**Kittitas County**  
**Teanaway Solar Reserve**

**Public Comments**  
**After March 23, 2010**

Re: CU 09-00005

Thank you for the opportunity to comment on the pre-threshold determination for the Teanaway Solar Project, proposed by Teanaway Solar Reserve (TSR). We have reviewed the supplemental application documents, as well as, the expanded environmental checklist and have the following comments.

**FIGURE 2**  
**Proposed Site Layout**  
 Vegetation Management Plan  
 Teanaway Solar Reserve  
 Kittitas County, Washington

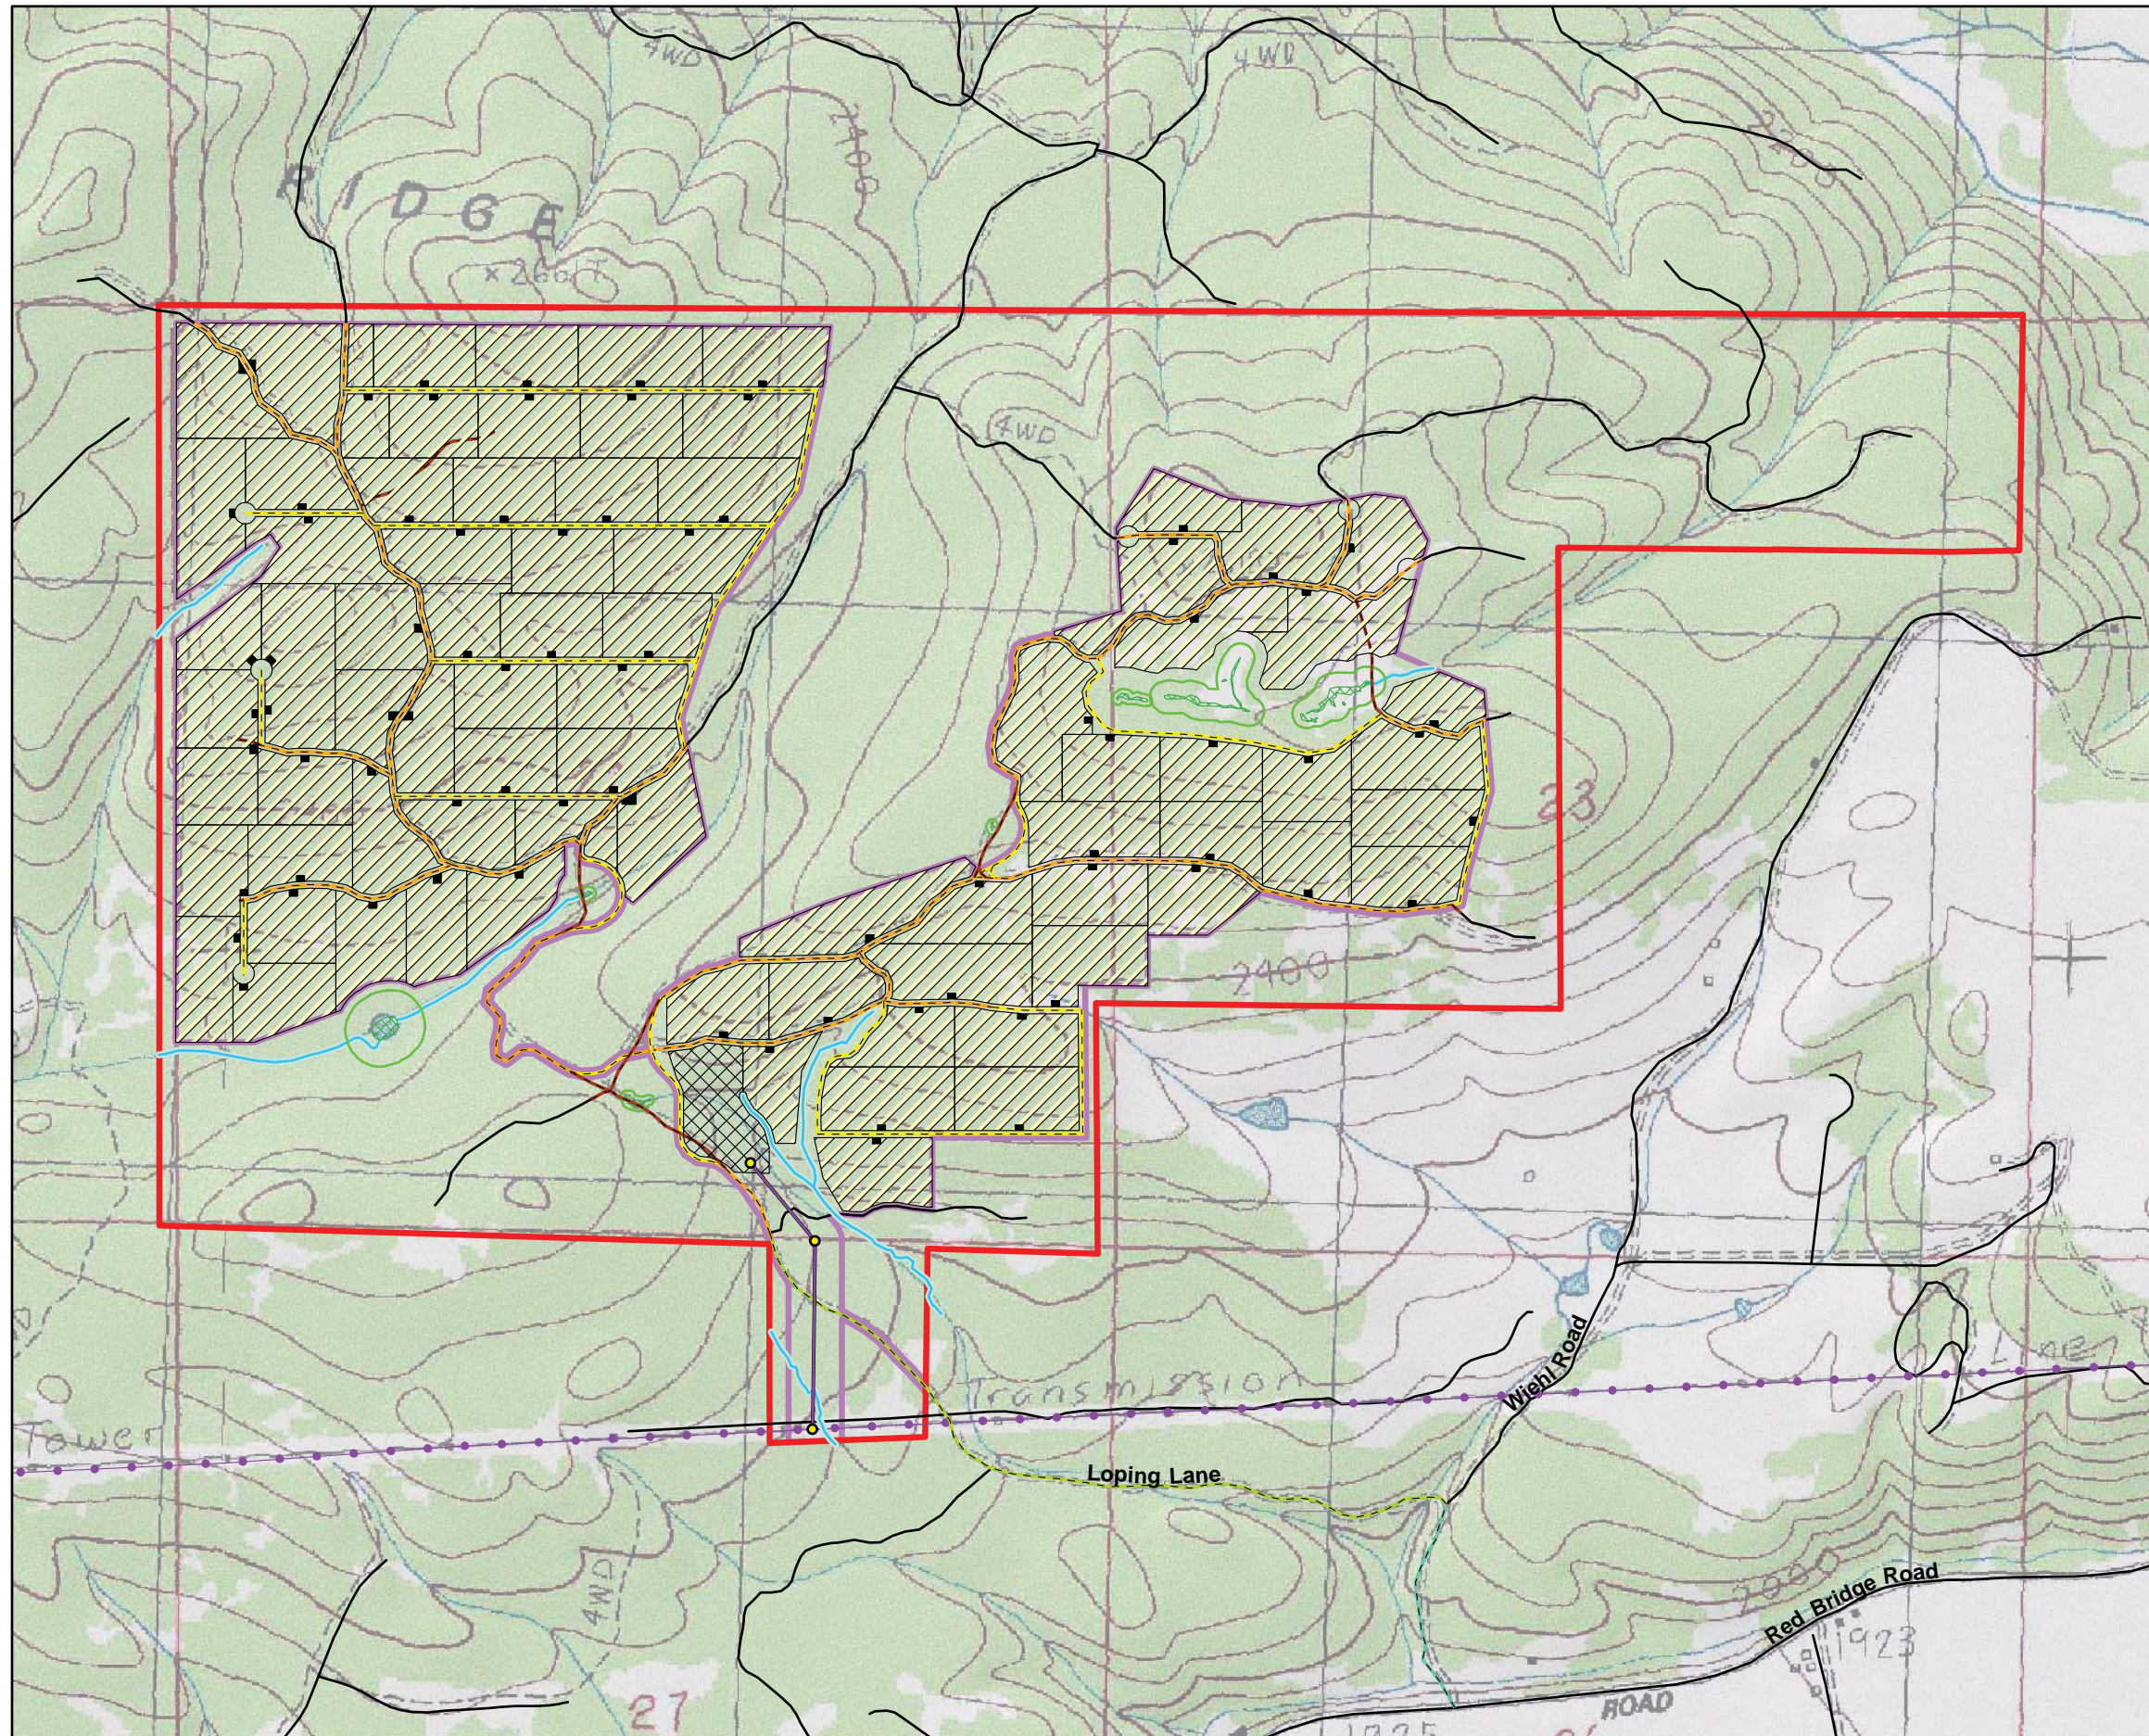
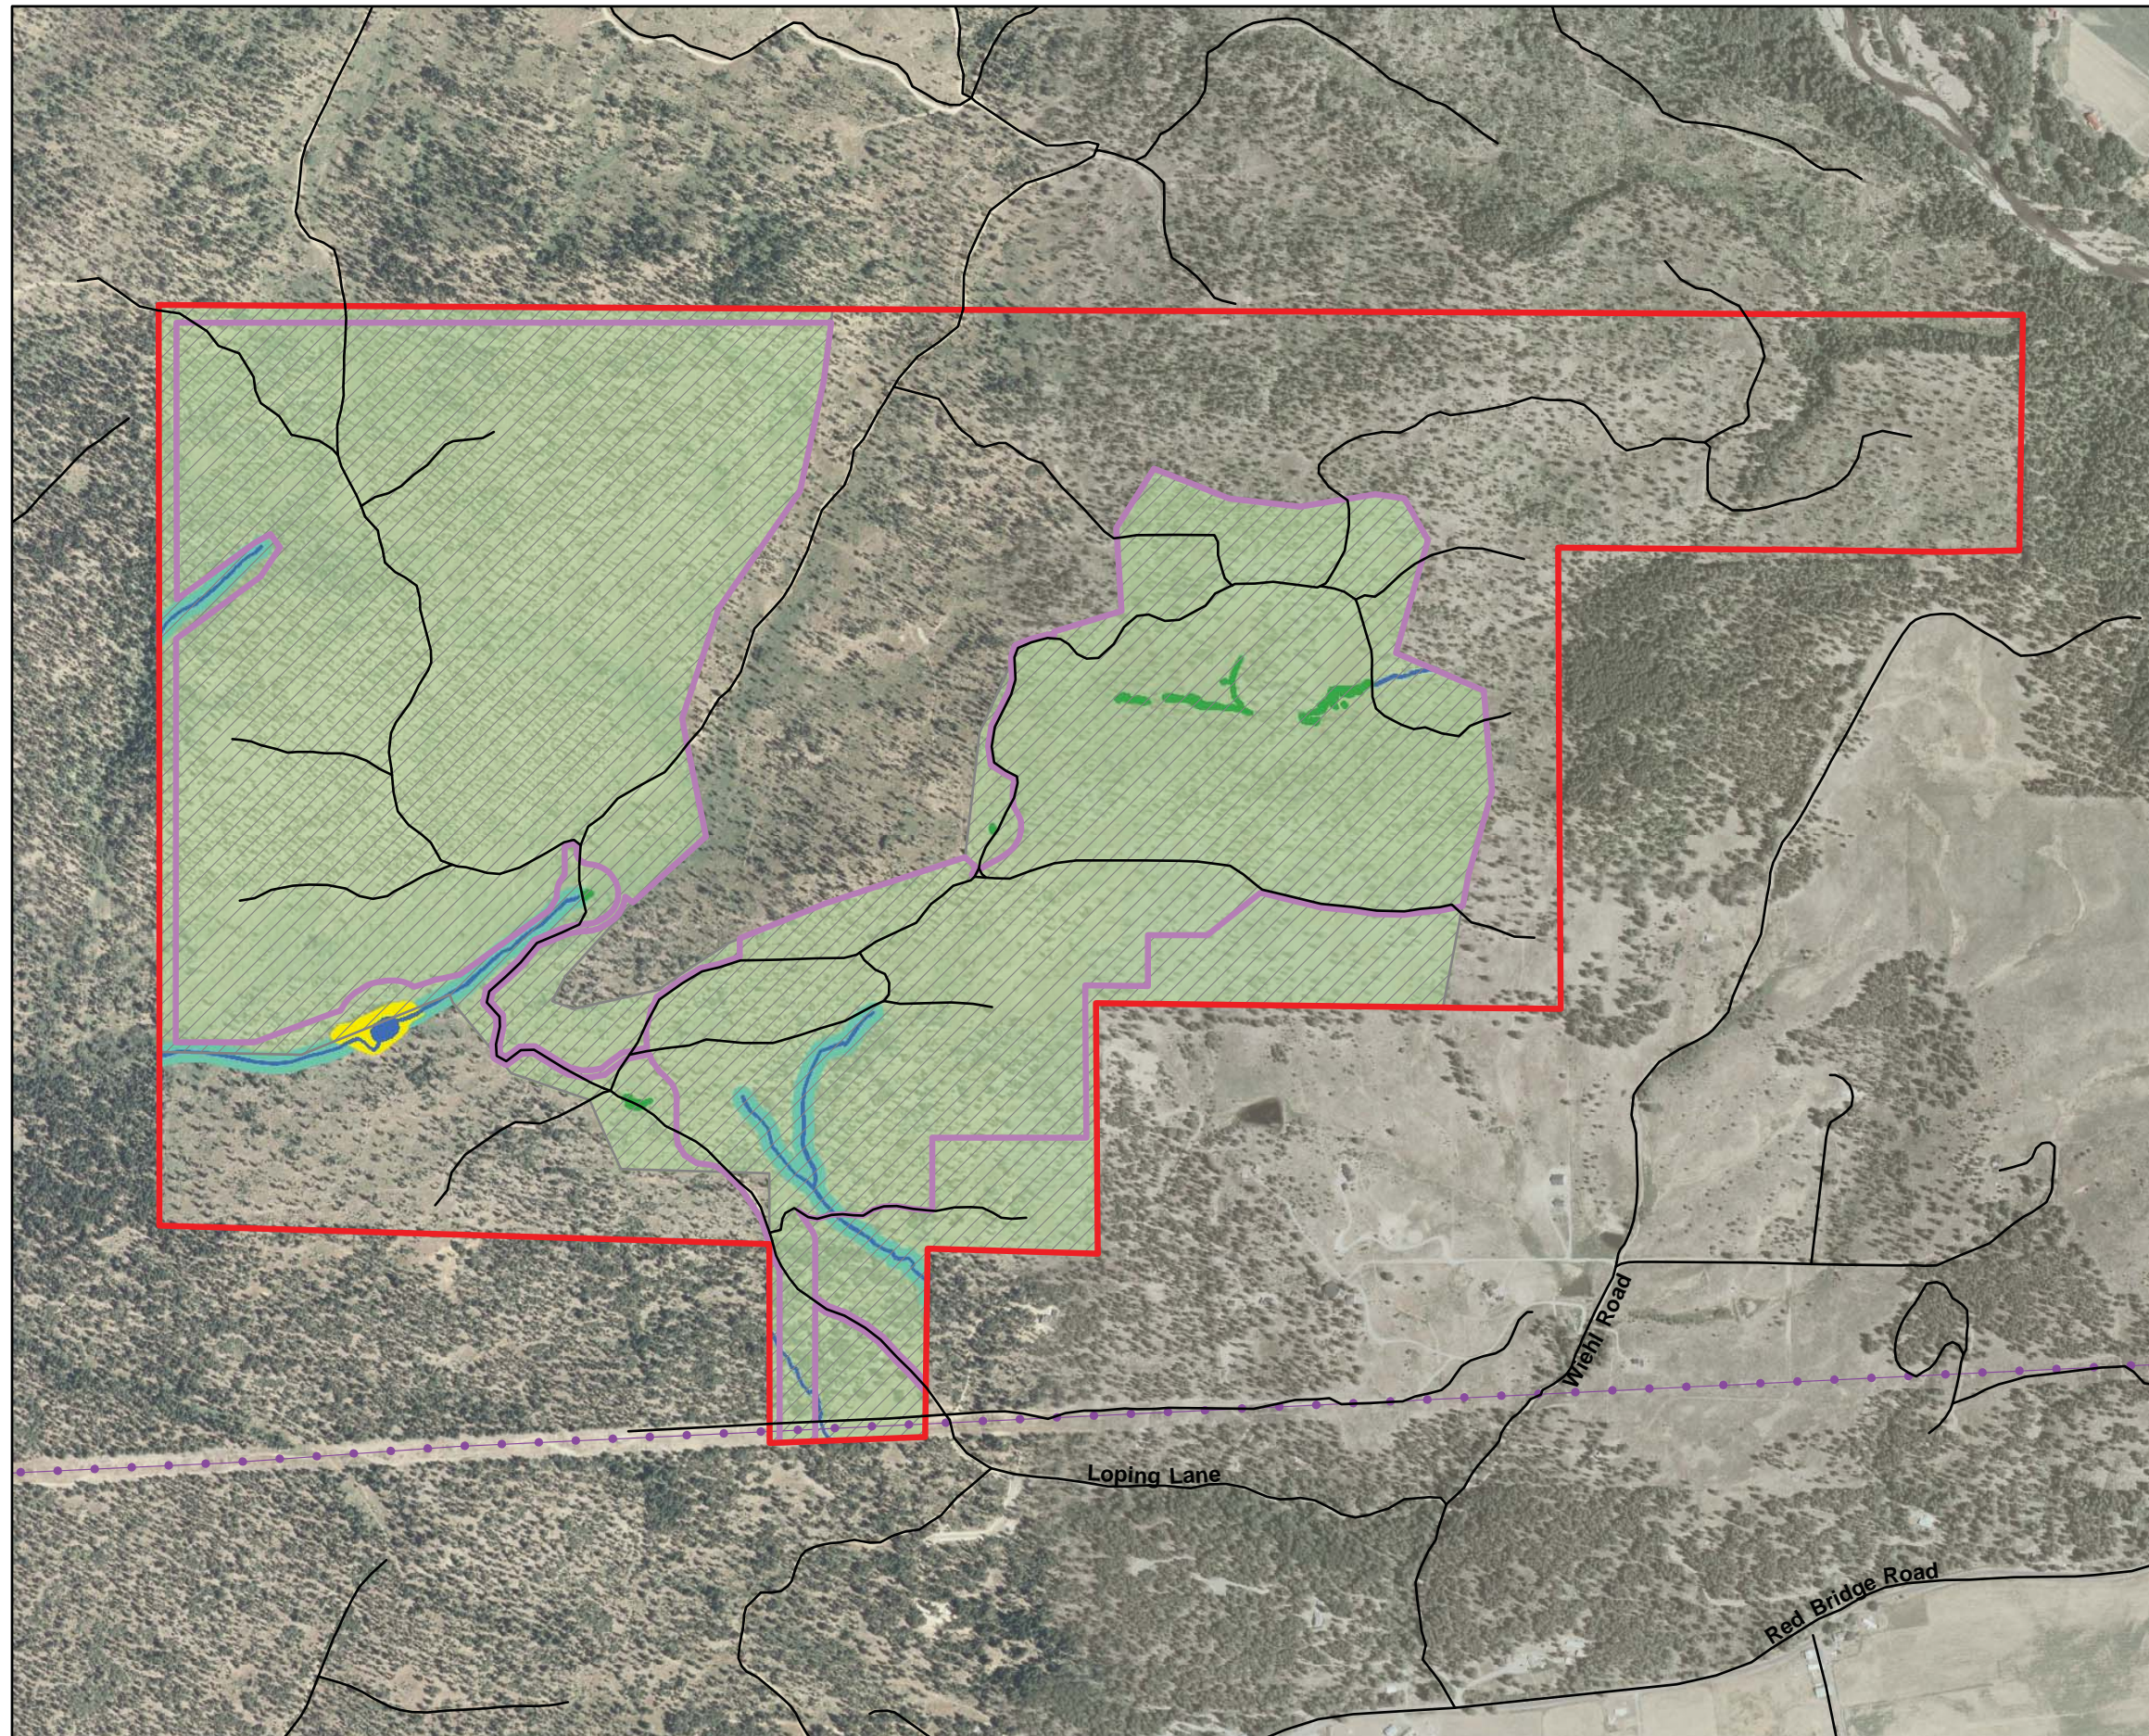
2. The current site hydrology report indicates that there are two main runoff areas, one to the north and one to the south. However, during development of the NPDES stormwater permits, TSR should identify the minor sub-basins in the project area. CH2M Hill personnel have estimated that there may be ten or more minor sub-basins on the project site.

7. Using low impact development and construction techniques during project design, wherever possible, will decrease project impacts to water quality.
8. During the field tour, we noticed that an area in the lower southeast corner of the project (see yellow circle on map, to right) was wet with standing/flowing water and some indication of wetland vegetation. This area is marked on topographic maps as a stream, and it appears to be "Stream S2" in the TSR's wetland delineation report. However, the project site map shows that the current plan is to completely cover this area with solar arrays. This corner of the project also has a setback of only 100' from the neighboring (downhill) property, which may restrict installation of successful long-term stormwater management BMPs at this location. Because this area could become a runoff and erosion problem in the future, Ecology recommends that this portion of the site be re-evaluated before final site design is completed.
